CUMBERLAND
CITY COUNCIL

**CUMBERLAND CITY COUNCIL SUBMISSION ON THE SYDNEY METRO WEST – RAIL
INFRASTRUCTURE, STATIONS, PRECINCTS AND OPERATIONS (SSI-22765520)**

Figure 7-1 Indicative layout and key design elements – Westmead metro station

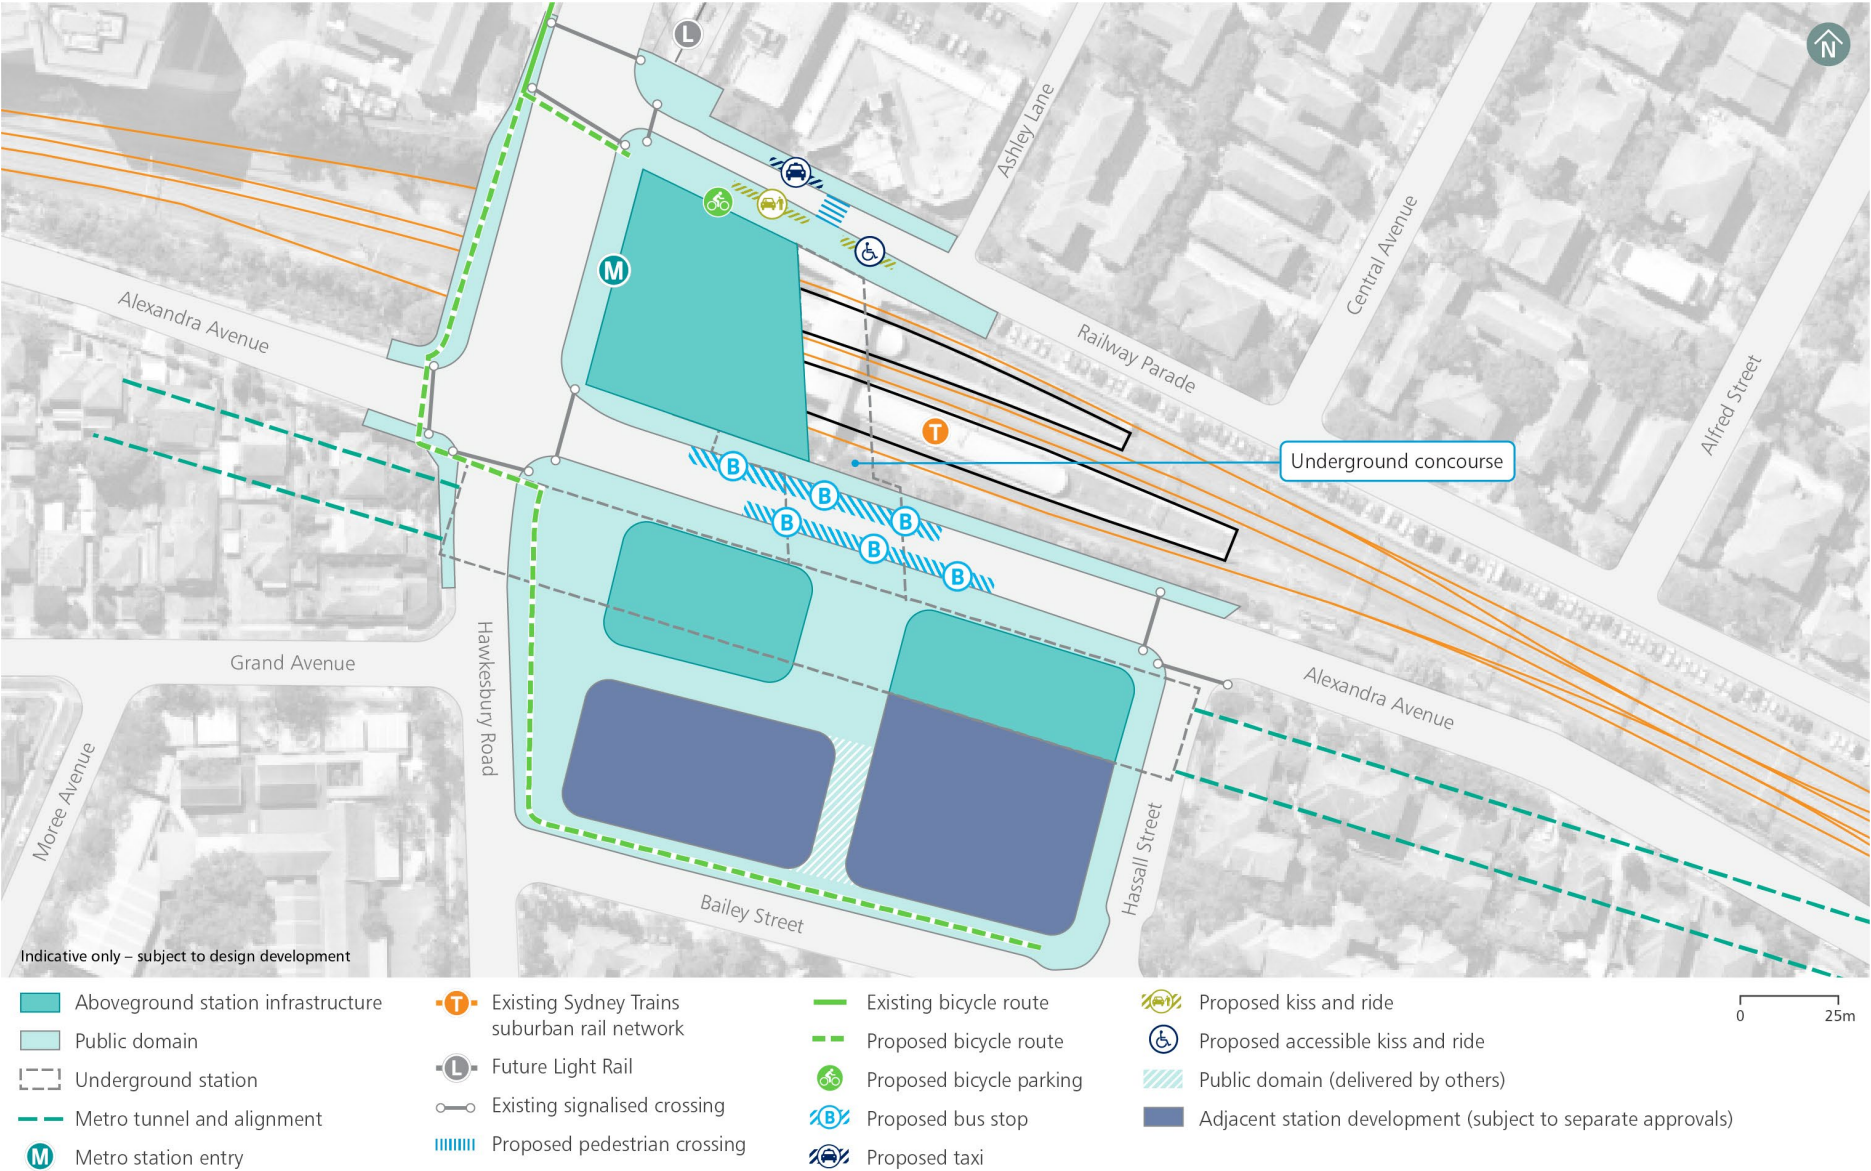
It should also be noted that Figure 7-3 in Chapter 7 shows Metro station entries on Alexandra Avenue and Railway Parade, which contradicts with the single Metro station entry shown on Figure 7-1. Council seeks clarification on this matter.

Figure 7-1 of Chapter 7 outlines transport interchange facilities to support users of the transport hub. The following facilities have been proposed:

- Reinstatement of the pedestrian crossing on Railway Parade
- Bicycle parking on Railway Parade
- Taxi bay on Railway Parade
- Kiss and ride bay on Railway Parade
- Proposed accessible kiss and ride bay on Railway Parade

These facilities would be concentrated to the north of the transport hub and would require travellers with origins or destinations to the south to travel longer distances to access them, increasing travel time and distance and pedestrian flows to the north, and which would have an adverse impact on safety and network performance.

Figure 7-1 (Chapter 7) shows that multiple crossings of Hawkesbury Road would be required by cyclists navigating the station area and the Hawkesbury Road overbridge when coming/going from the eastern side of Hawkesbury Road on both the northern and southern sides of the rail line. This proposed route is inconvenient and disruptive for people travelling on bicycles through this area.

- Council recommends the formulation of urban heat mitigation strategies as the plaza will be exposed to both winter and summer sun.
- Council recommends that a separated cycleway on the western side of Hawkesbury Road and south of Alexandra Avenue (as identified in multiple studies carried out by various government agencies) should form considerations in how the transport hub will be accessed from the south and this cycleway should also be indicated in relevant parts of the EIS (e.g., Figure 7-1).
